Engineers Comments Regarding Surface Water Drainage

Application Reference:	BN/76/26/DOC	Reviewer Reference:	ADC/EXT2/113
Planning Officer:	Amber Willard	Date of Review:	30/07/2026
Site Name:	Land South Of Wandleys Lane Eastergate PO20 3SE		
Application Description:	Approval of details reserved by condition under BN/46/25/PL relating to conditions 4- Surface Water Drainage and 9- Maintenance & Management of Sustainable Drainage Scheme.		
Assessment Number:	1

Response	Condition 4: Further information required Condition 9: Further information required
-----------------	---

Date	09.02.26	Scale	1:10 @ A1	Dwg. No.	476988/912 P03
Drawn	SWF	Chk'd	TB	QA'd	TB

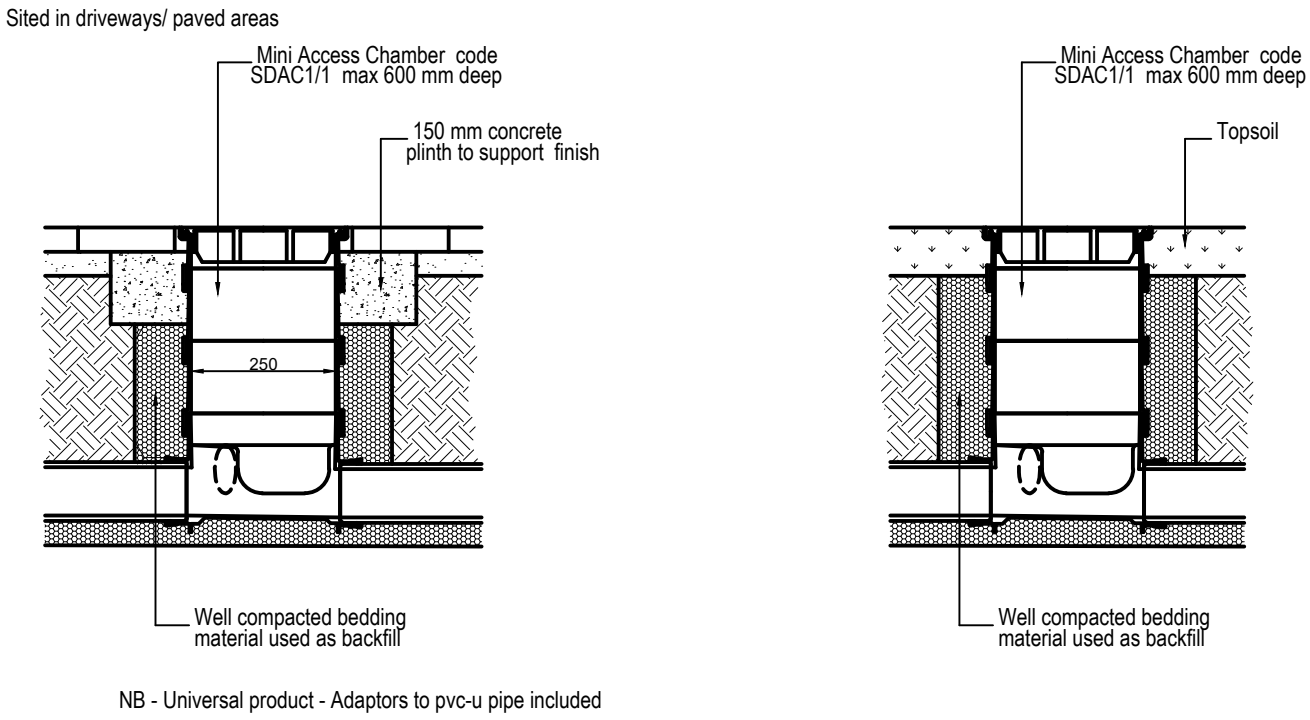
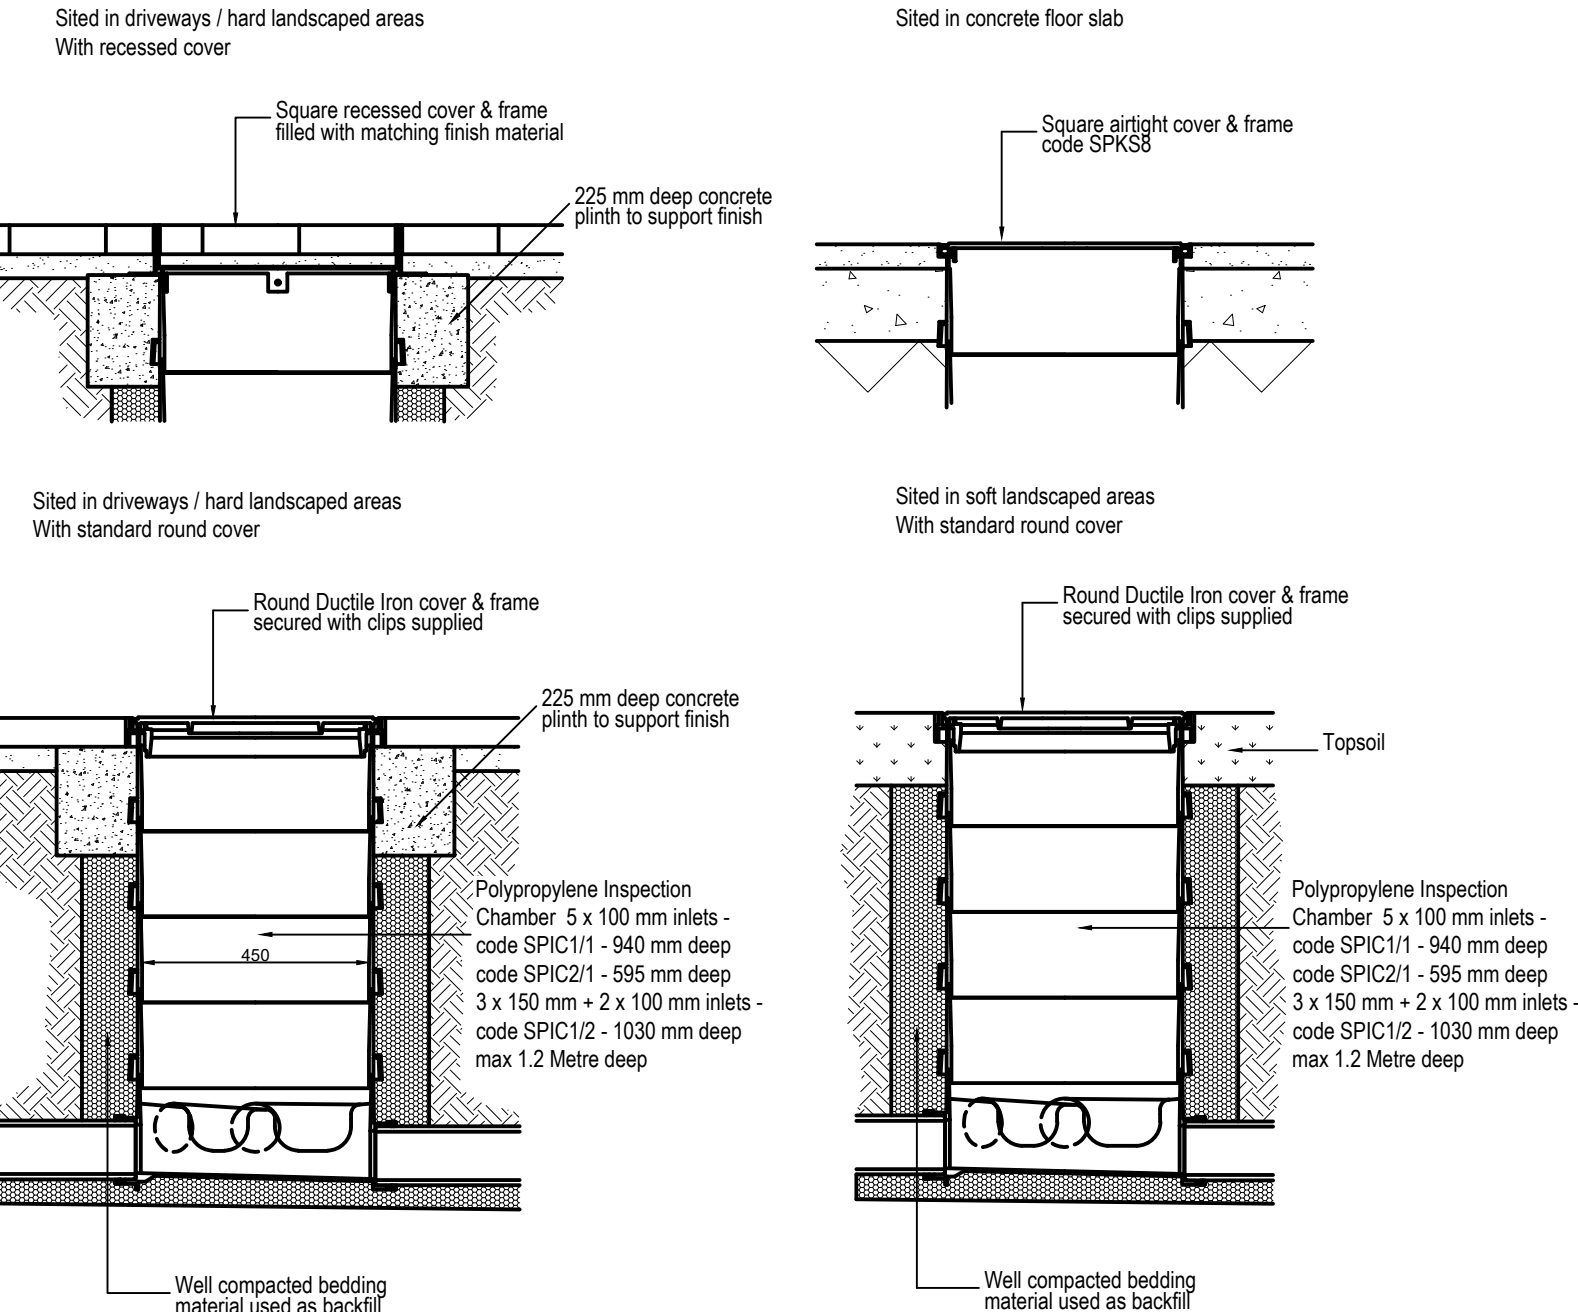
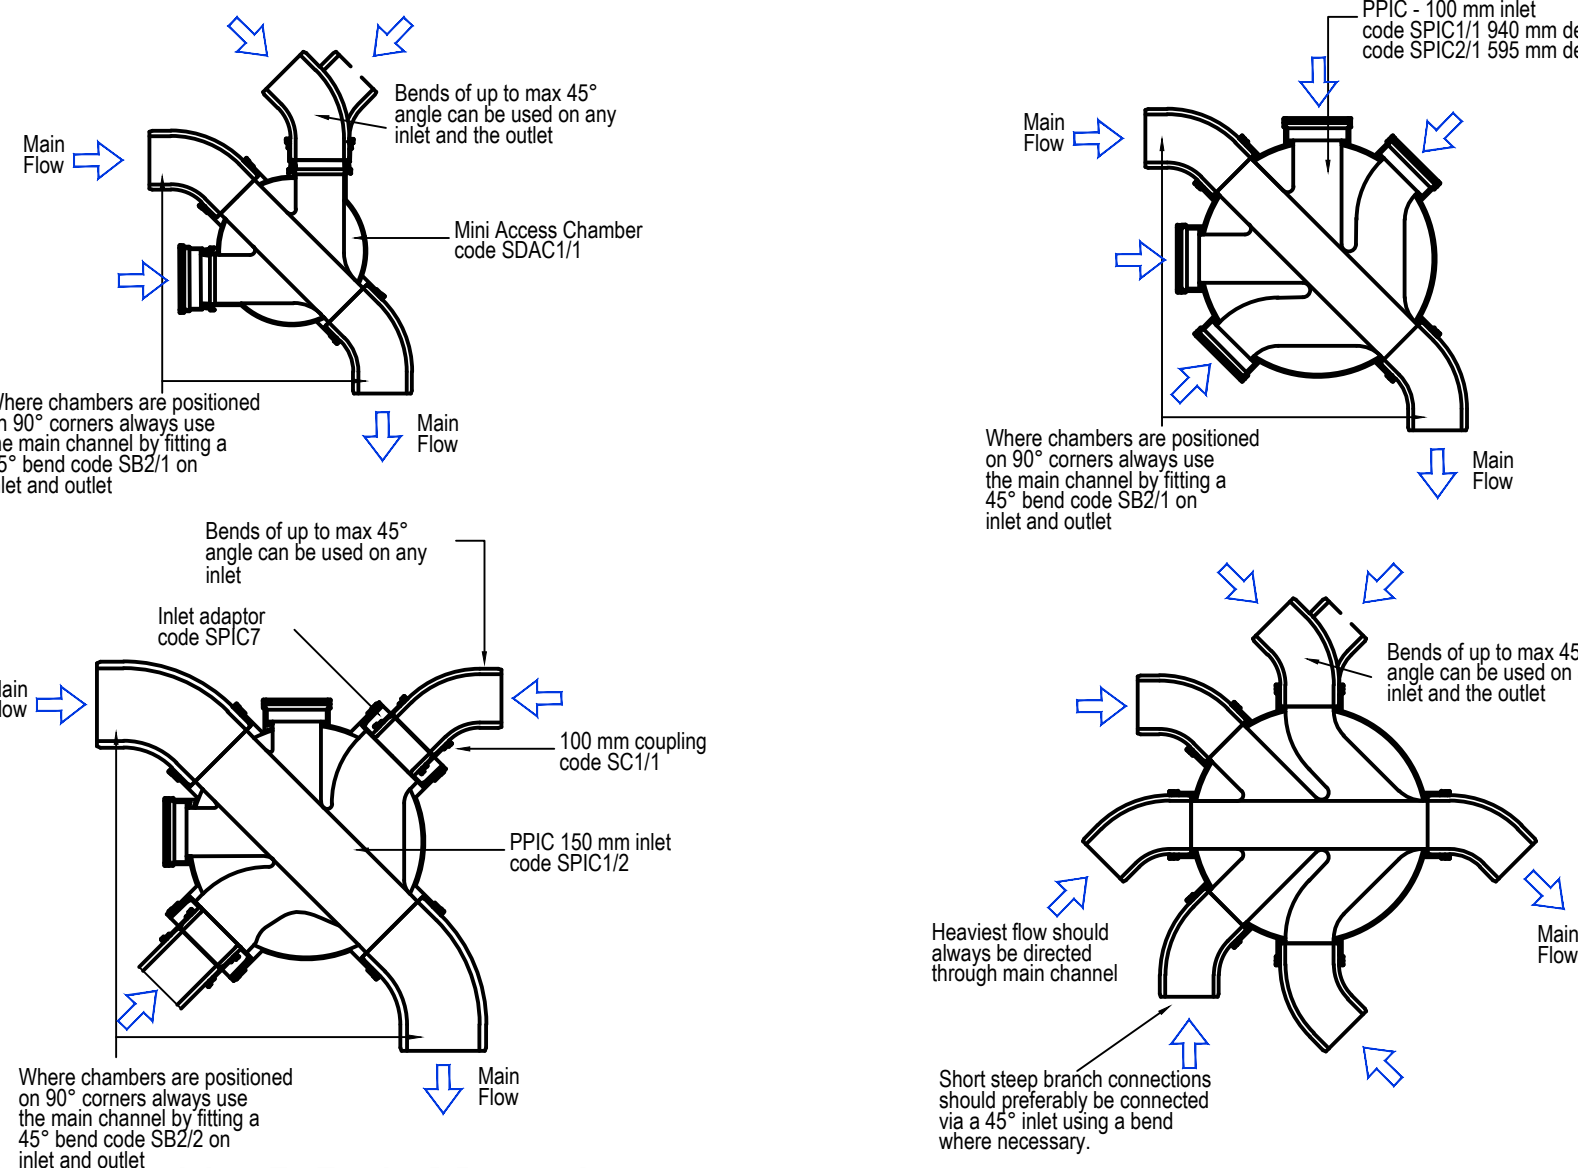
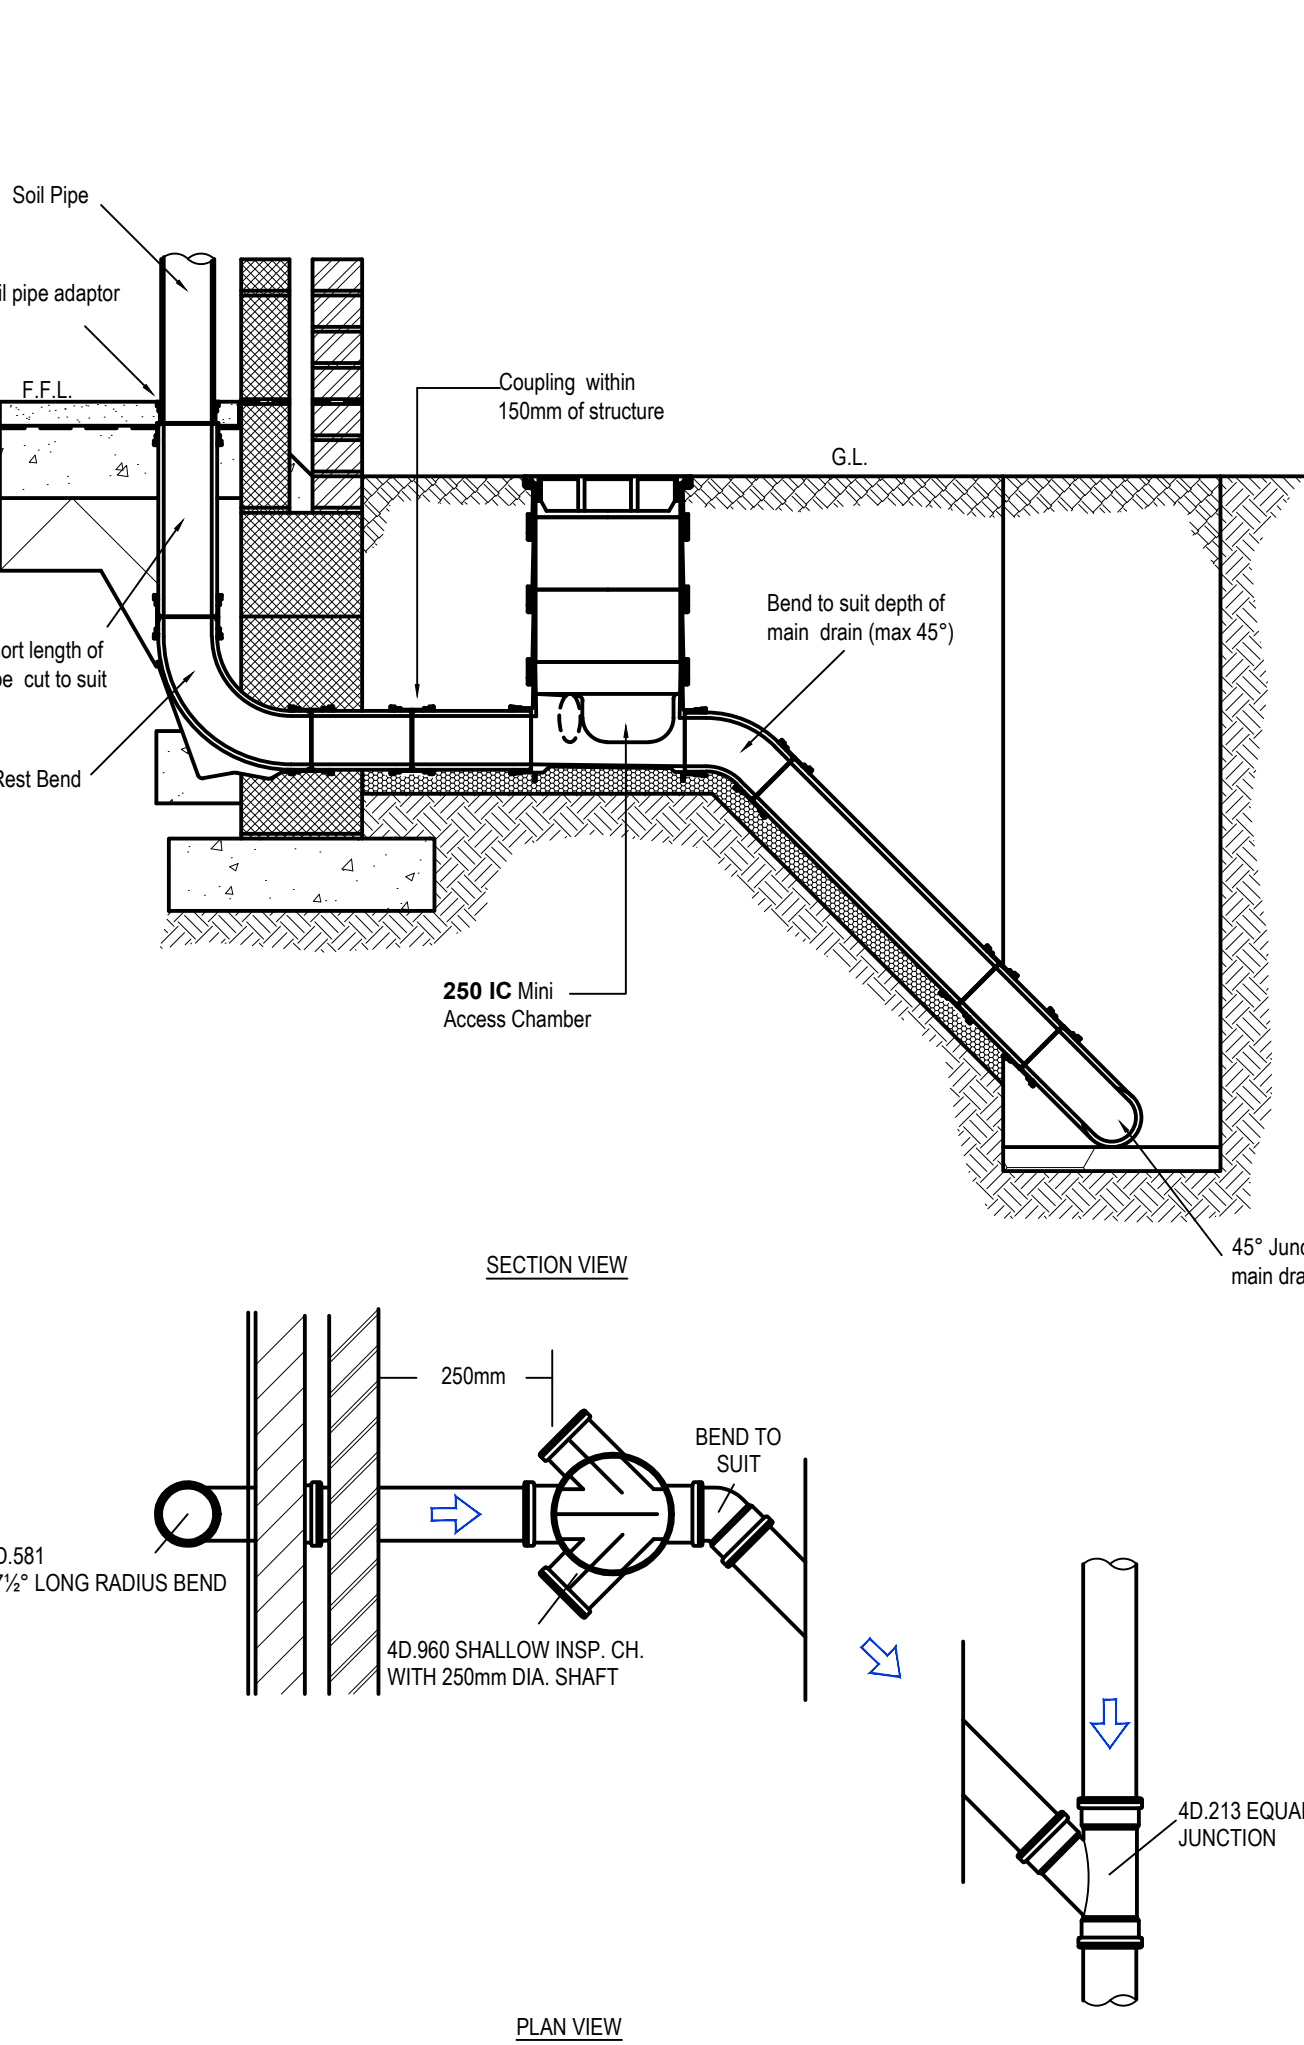
i.e. CBR's or pipe bedding requirements etc.	to be located at least 5m from a dwelling Soakaway rule).			
		Comment outstanding.			
29.	Inspection chamber types have been added to the construction details. Please refer to drg no. 476988-912_P03 – Construction Details-- Sheet 2.	Noted. Comment closed.
